6 November 2020

**Kings Park Metal Recovery and Recycling Facility Expansion (SSD-10396)  
Request for Additional Information**

## ATTACHMENT 1

SWEPT PATH ANALYSIS
19m ARTICULATED VEHICLE - HEAVY / DANIELLI SHEAR

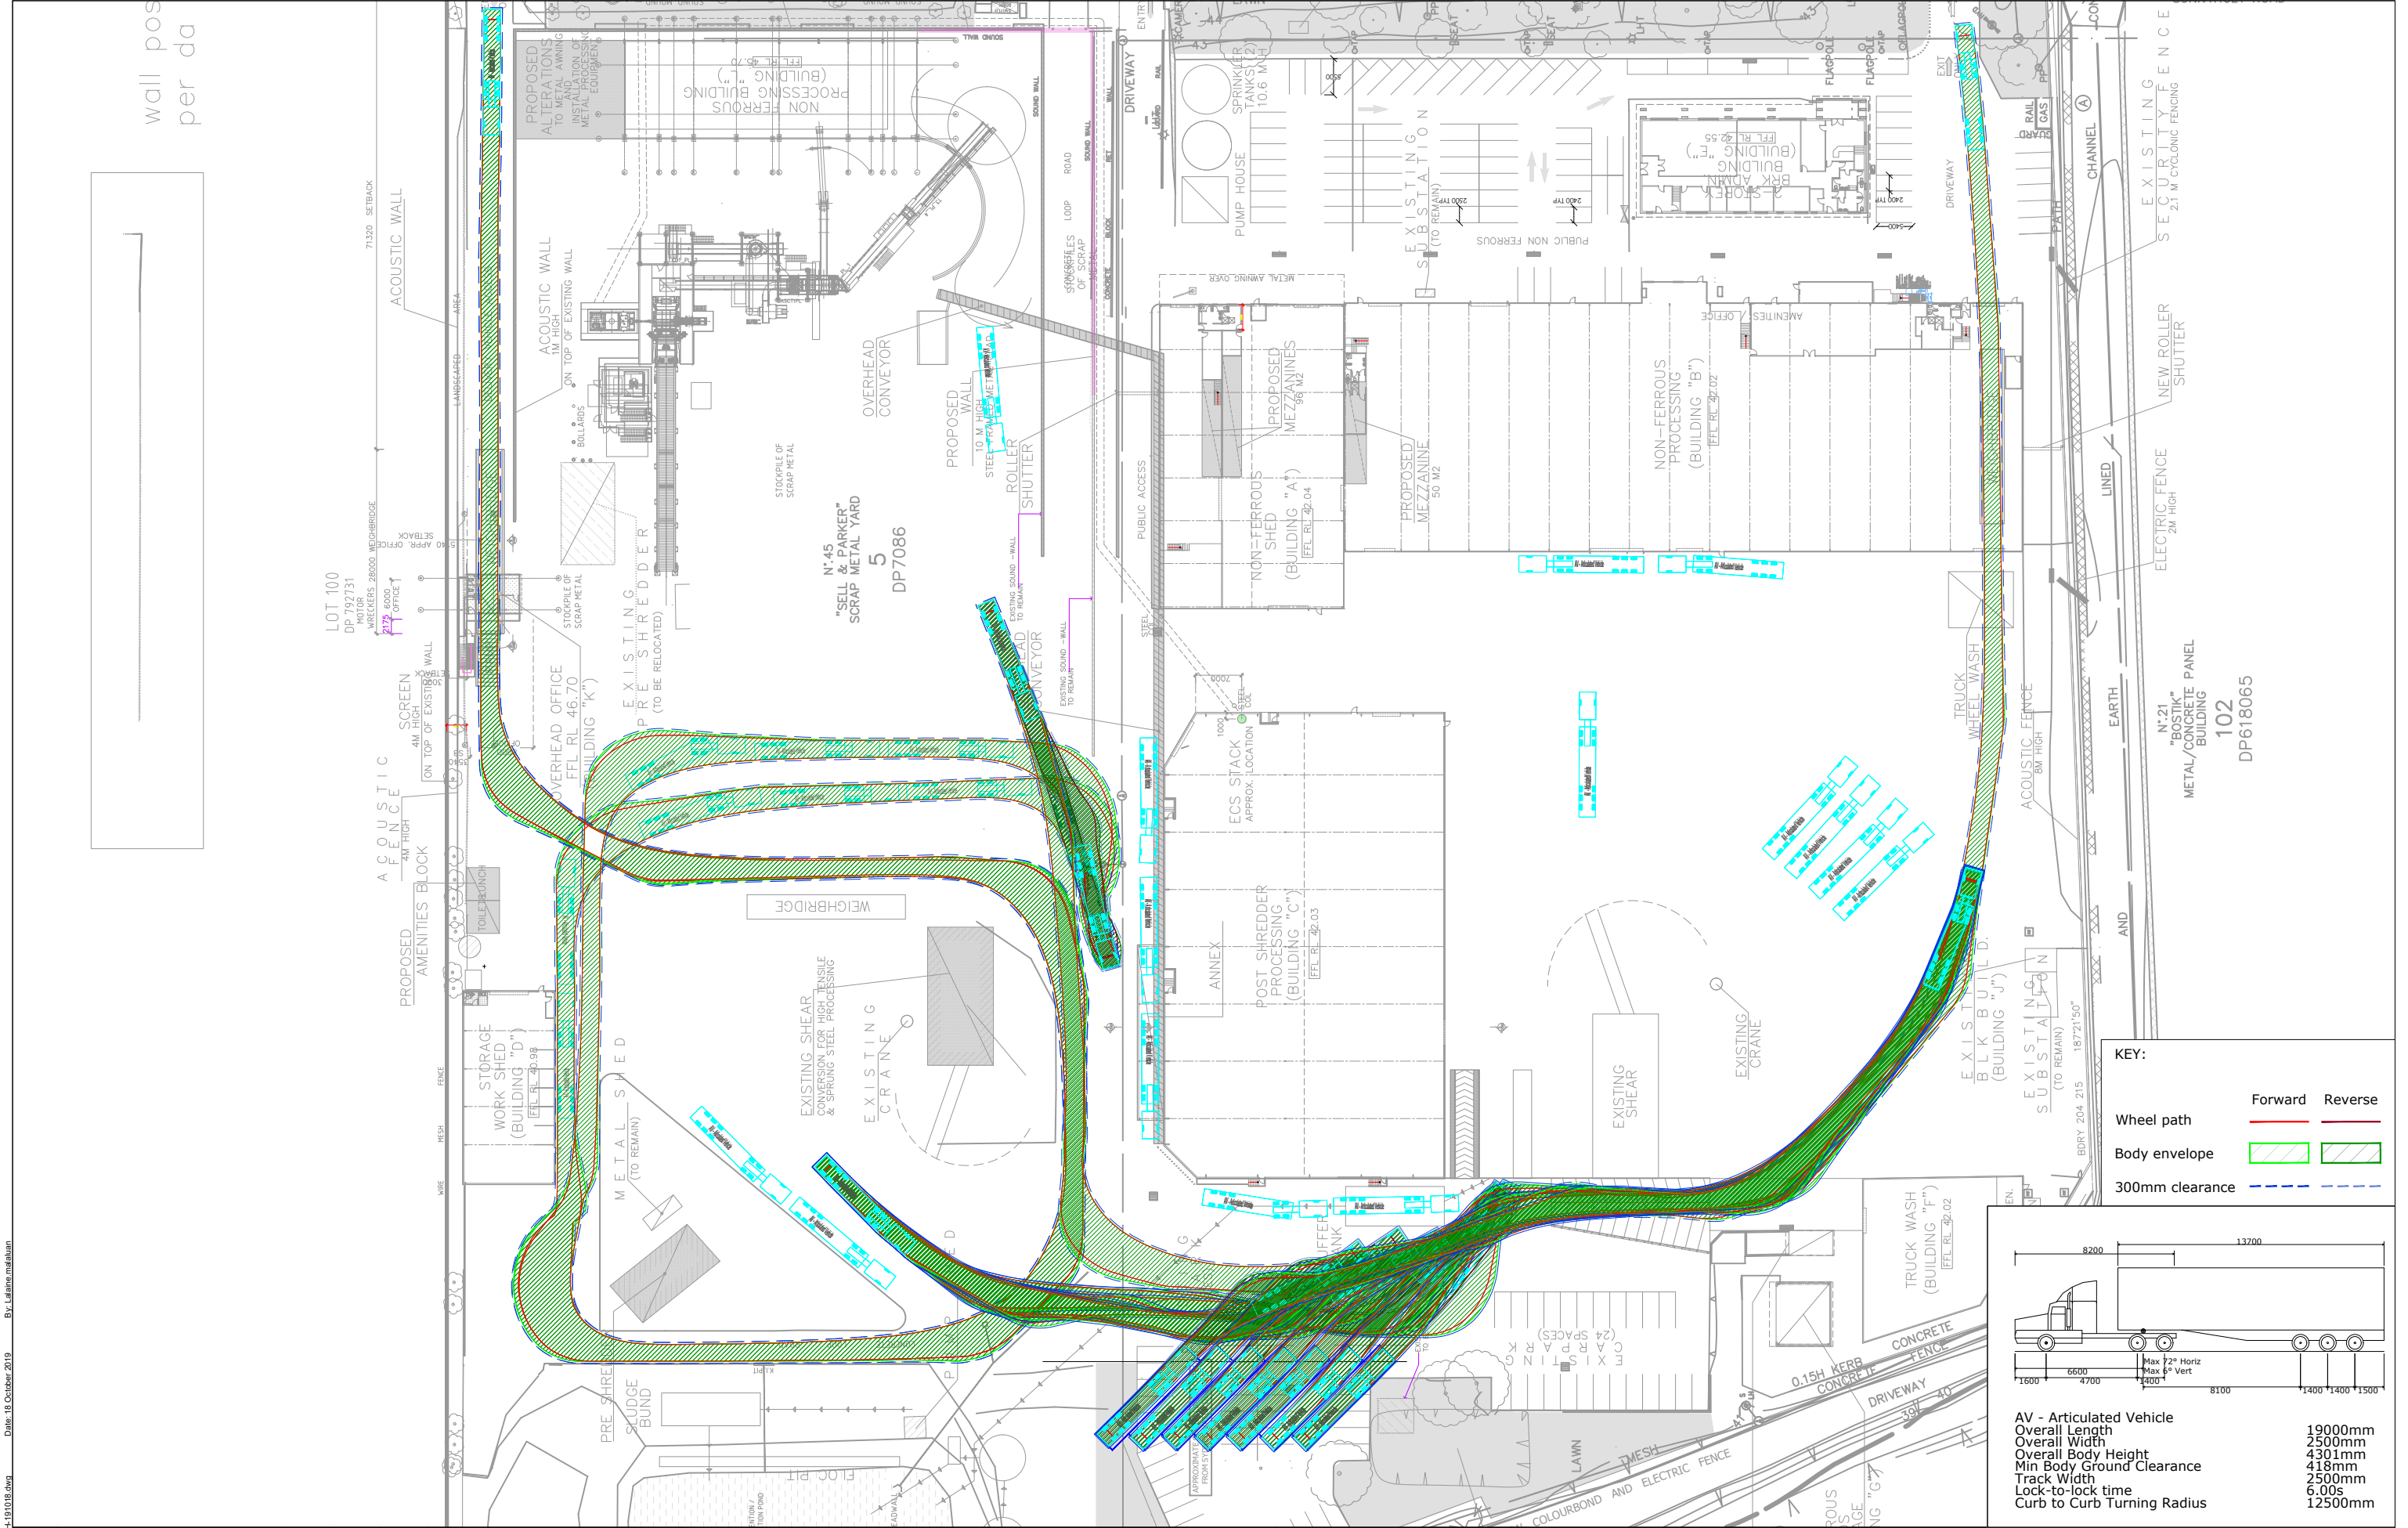
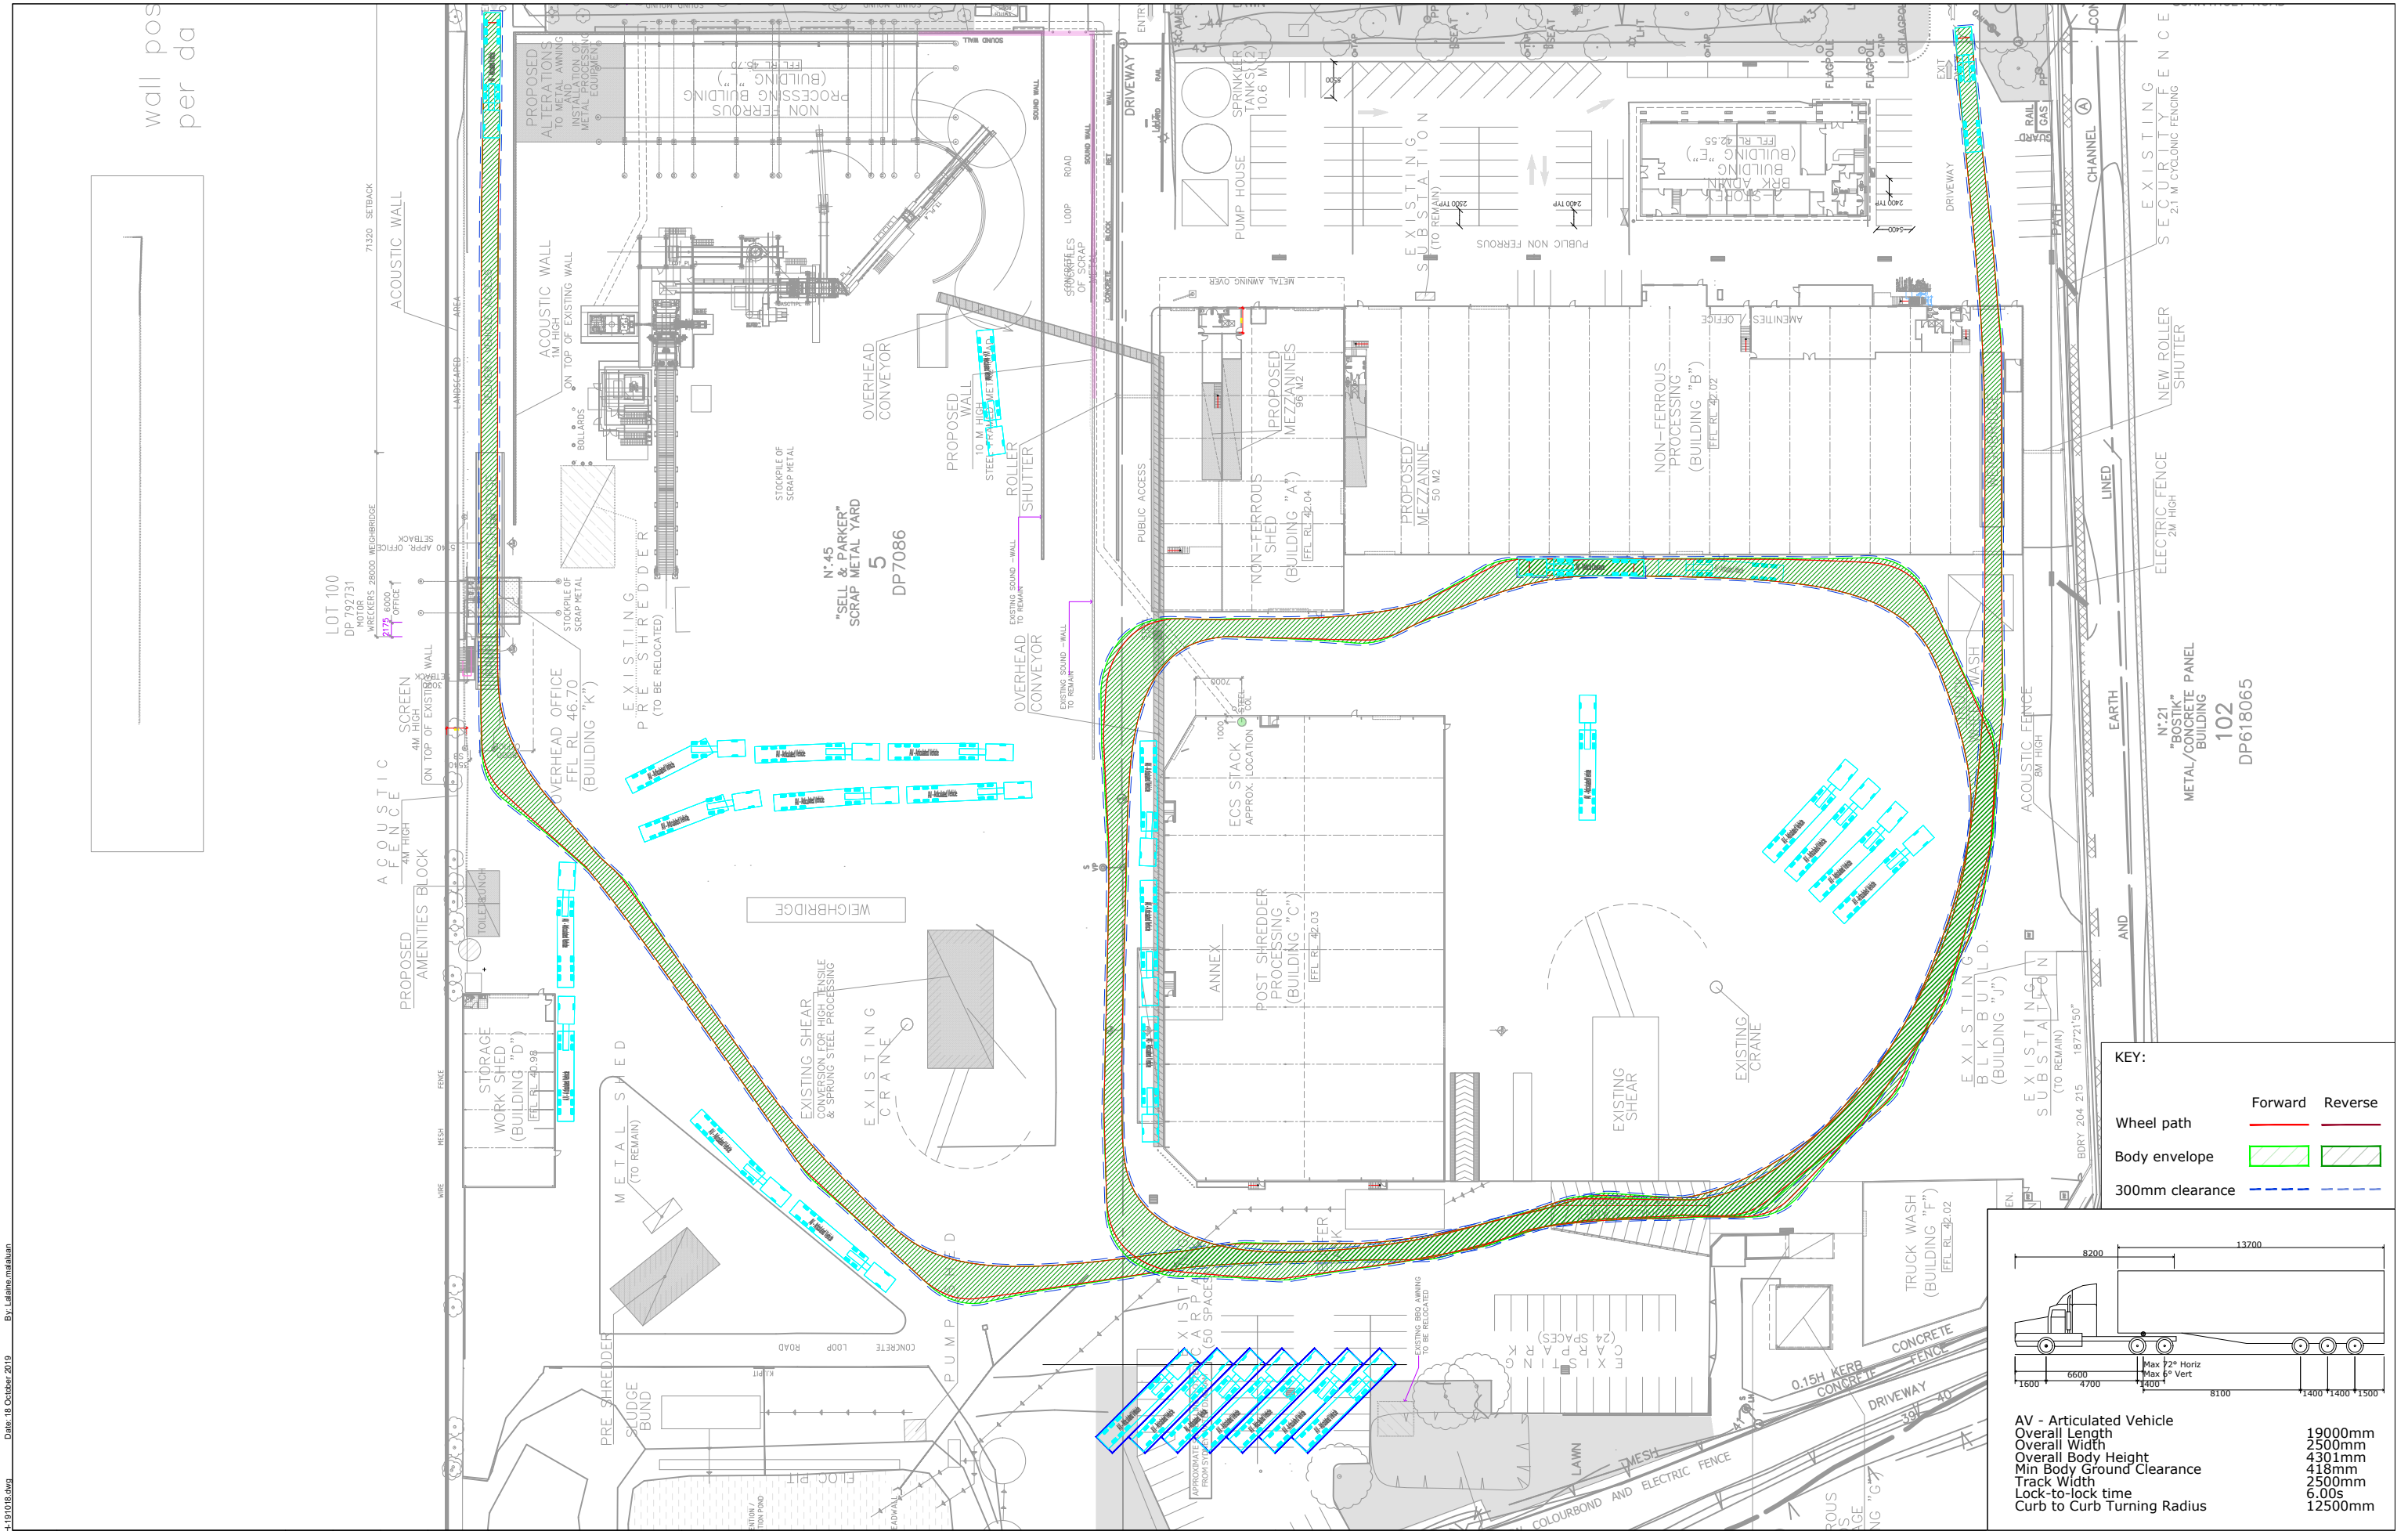
- It is noted the site has three weighbridges: one entry, one exit and one adjacent to one of the shears. Please explain the purpose of the central weighbridge. If its use is associated with the central entry (non-ferrous material), please explain why its use is not shown on the swept path analysis for those vehicles using the central entrance.

- It is noted the assessment identifies peak periods which were used to assess impacts across the scenarios. Please clarify whether these are peak periods for the road network or for the facility.
- It is noted that swept paths have been provided, however, the plans do not include stockpiles. Please update the plans to include stockpiles and ensure the swept path analysis demonstrates that vehicles can safely access the relevant stockpile.
- Table 6.2 in the traffic assessment provides a Stacking Capacity Assessment, however it is unclear whether the number of vehicles accessing the site in an hour represents peak operational periods. If not, please update the table for peak operational periods
